Case Officer: Catherine Harker **Recommendation:** Approve

Applicant: WH Brakspear and Sons Ltd

Proposal: Part Retrospective update/refresh of the existing signage for The Lion.
New external lighting fixed to the exterior of the building to replace brass
swan-neck lighting installed without LBC (new lighting to replace the
"swan necks" has not yet been installed)

Hanging sign - 1 :10 scale

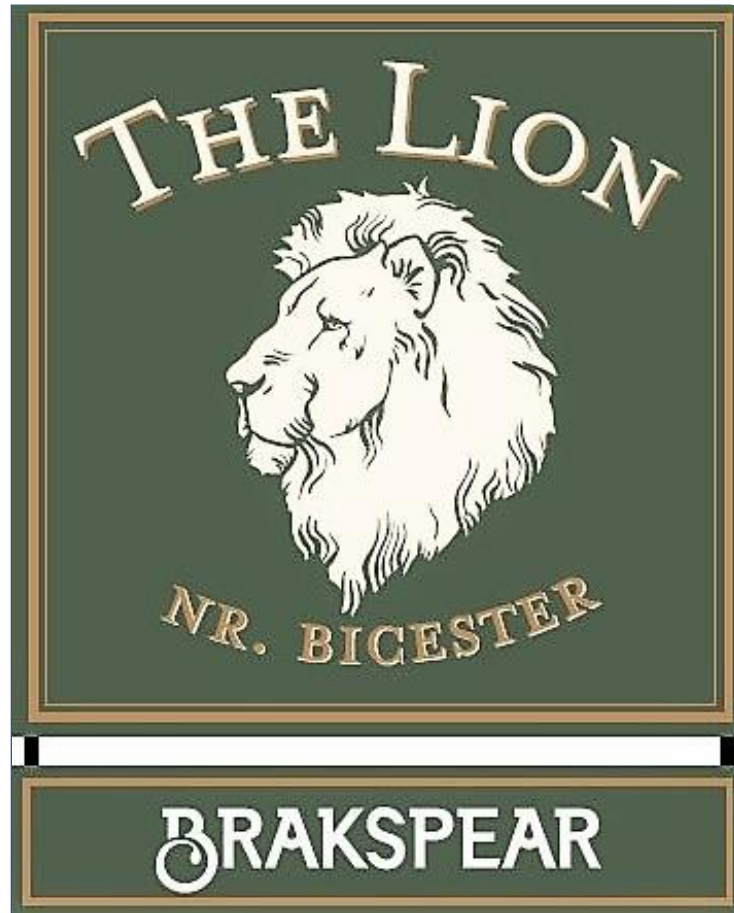
8.6. The timber hanging sign to the front elevation utilises the historic bracket, which is welcomed.

1:50 AAN.23.869.1

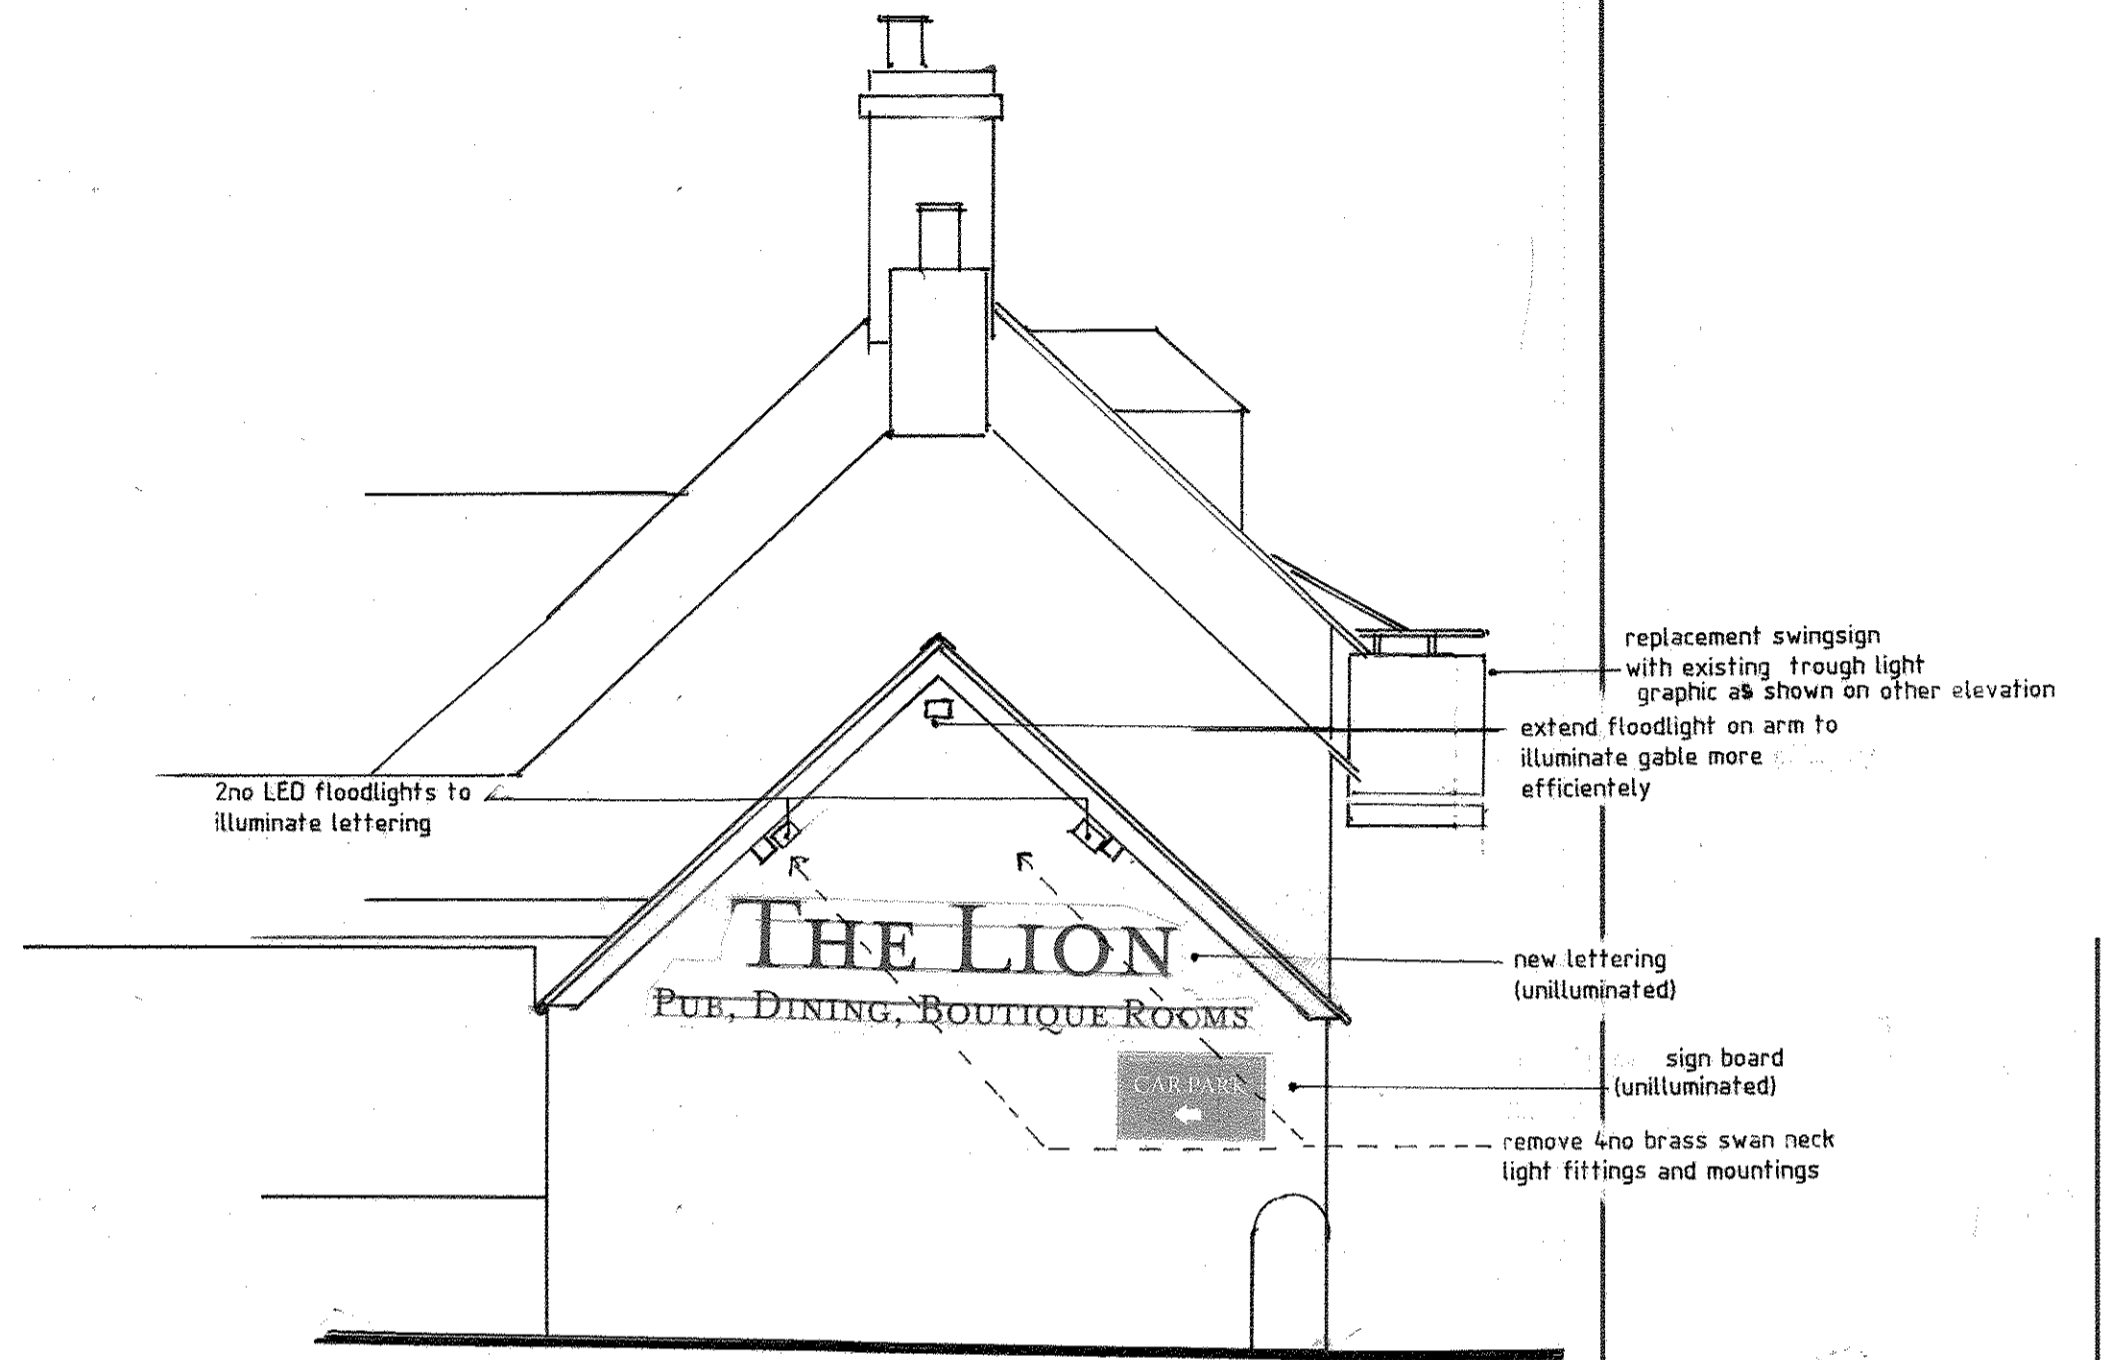
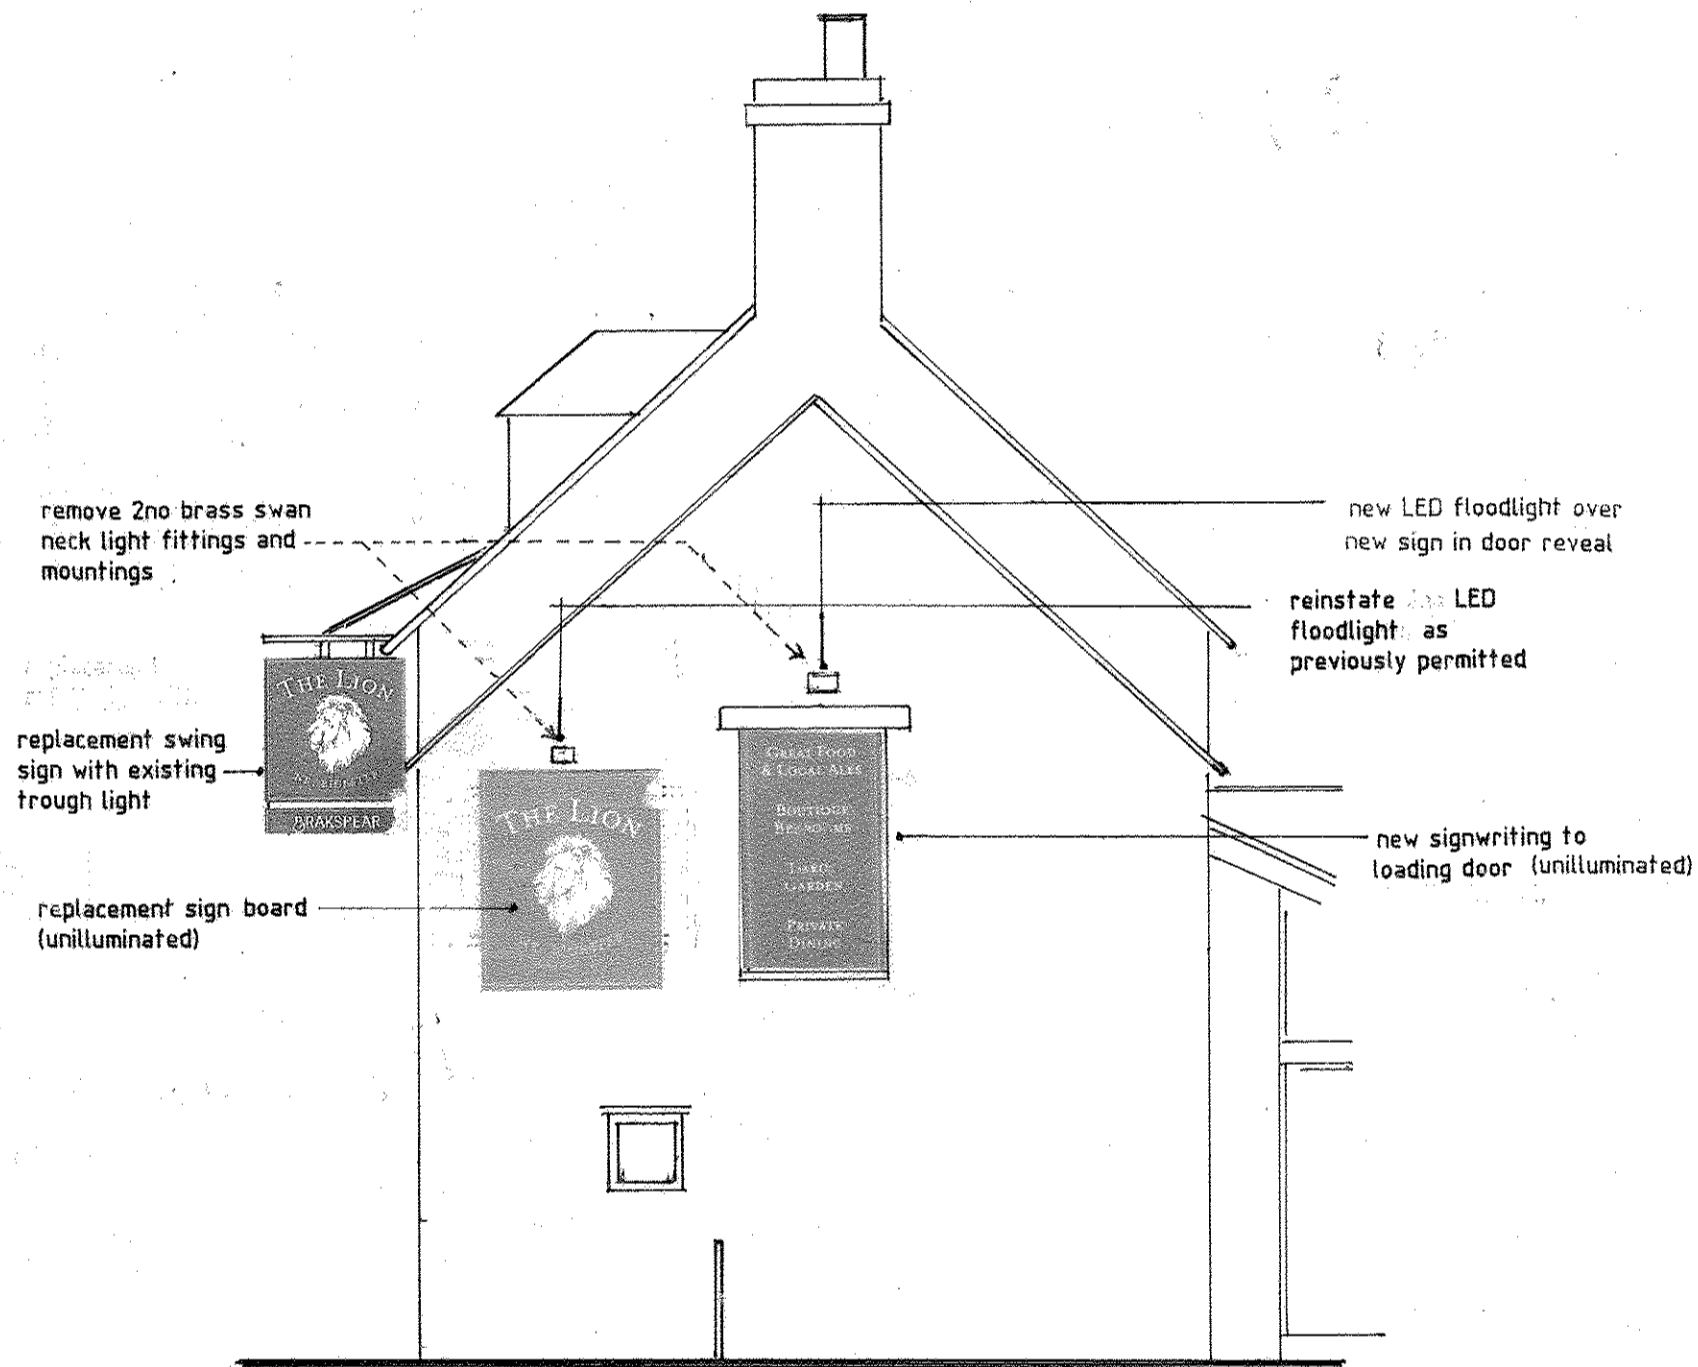
8.5. The new timber signs are considered to be of an appropriate material and colouring for a listed building, in accordance with the CDC Design Guide for Shop Fronts and Advertisements: Historic Buildings and Conservation Areas (2013) and although one of the signs is larger than previously, and slightly competes with the interesting historic first floor loading door on the south end elevation of the pub, it is not so large or obtrusive as to be harmful.

- 8.7. The gold metal lettering on the north elevation is considered somewhat more brash than the previous black painted sign, but this style of sign is common on older pubs and is not considered harmful to the character of the building. The revised lighting proposed, with simple hidden LED lights in place of the obtrusive swan neck lights is considered acceptable and in keeping with the advice in the CDC Design Guide for Shop Fronts and Advertisements: Historic Buildings and Conservation Areas (2013) for lighting.

- 8.8. The new parking sign and Real Ale sign over the existing door to the south elevation are also considered acceptable.
- 8.9. The removal of the unlawful swan neck lights which appear overly twee and incongruous with the simple character of this country pub, is welcomed.

Menu box

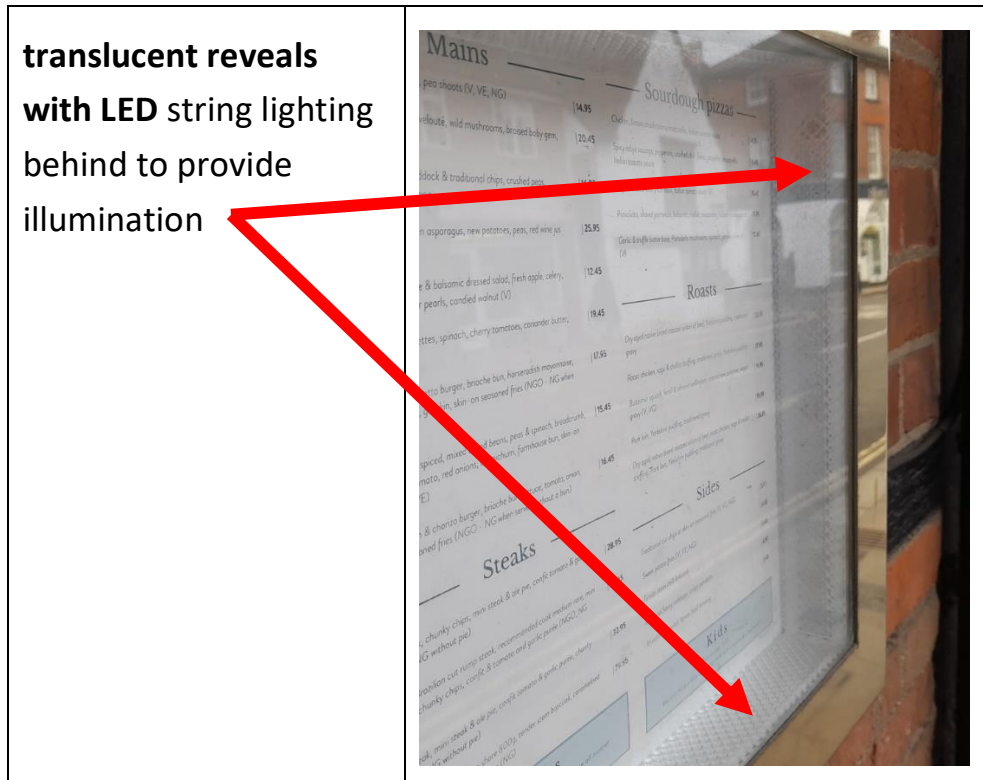
- 8.10. The new menu board is reasonably appropriate for the building, though the brass is a little bright, and would not result in harm to the significance of the listed building.
